# **Memo Report**

**From:** W. Mark Cummings, P.E.  
**To:** Mr. Steve Bushey, P.E.; Fay, Spofford & Thorndike, Inc. (FST)  
**Subject:** **Fire / Life Safety Code Review, ICW Boat Repair and Storage Facility at Canal Landing Boatyard**

**1** SIDEWALL DOOR FRAME DETAIL  
SCALE: 3/4" = 1'-0"

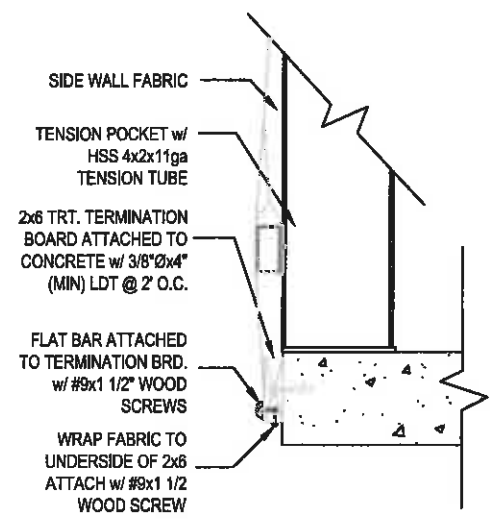
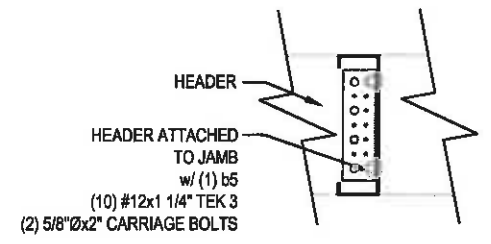
- Egress Capacity: Based on the five (5) personnel doors that are shown on the building plans, the means of egress could accommodate up to 750 people. At least one door is provided on each side of the building; with a second door being provided on the east wall. Based on the structural drawings, each door is assumed to be a standard 32” door. It is assumed that 30 inches of clear width are available at each door and an egress factor of 0.2 inches per occupant was applied (NFPA 101 Table 7.3.3.1 and IBC 1005.1).

S6.0

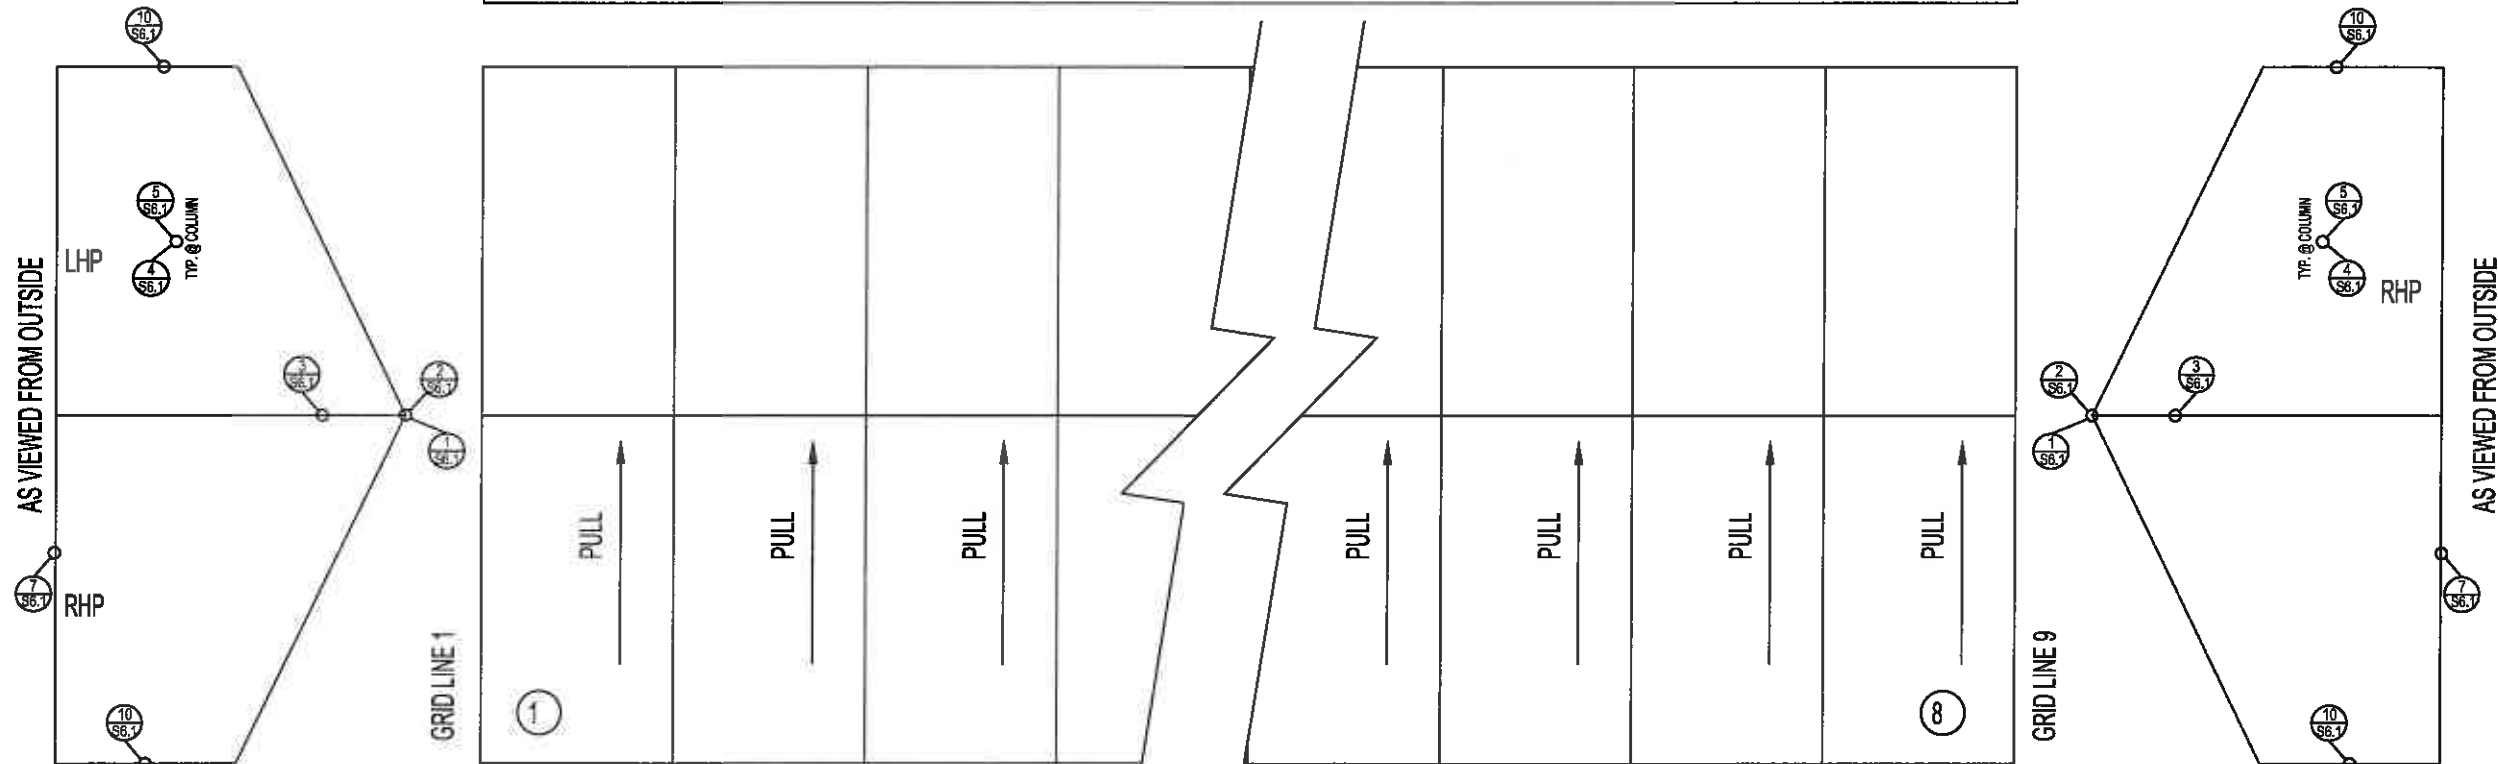
- Interior Finish: Minimum Class C permitted. The interior wall and ceiling finish is permitted to be Class A, B, or C in operating areas (NFPA 101 § 42.3.3 and IBC Table 803.9). The fabric that will form the exterior walls/ceiling does meet the requirements for a Class A rating.
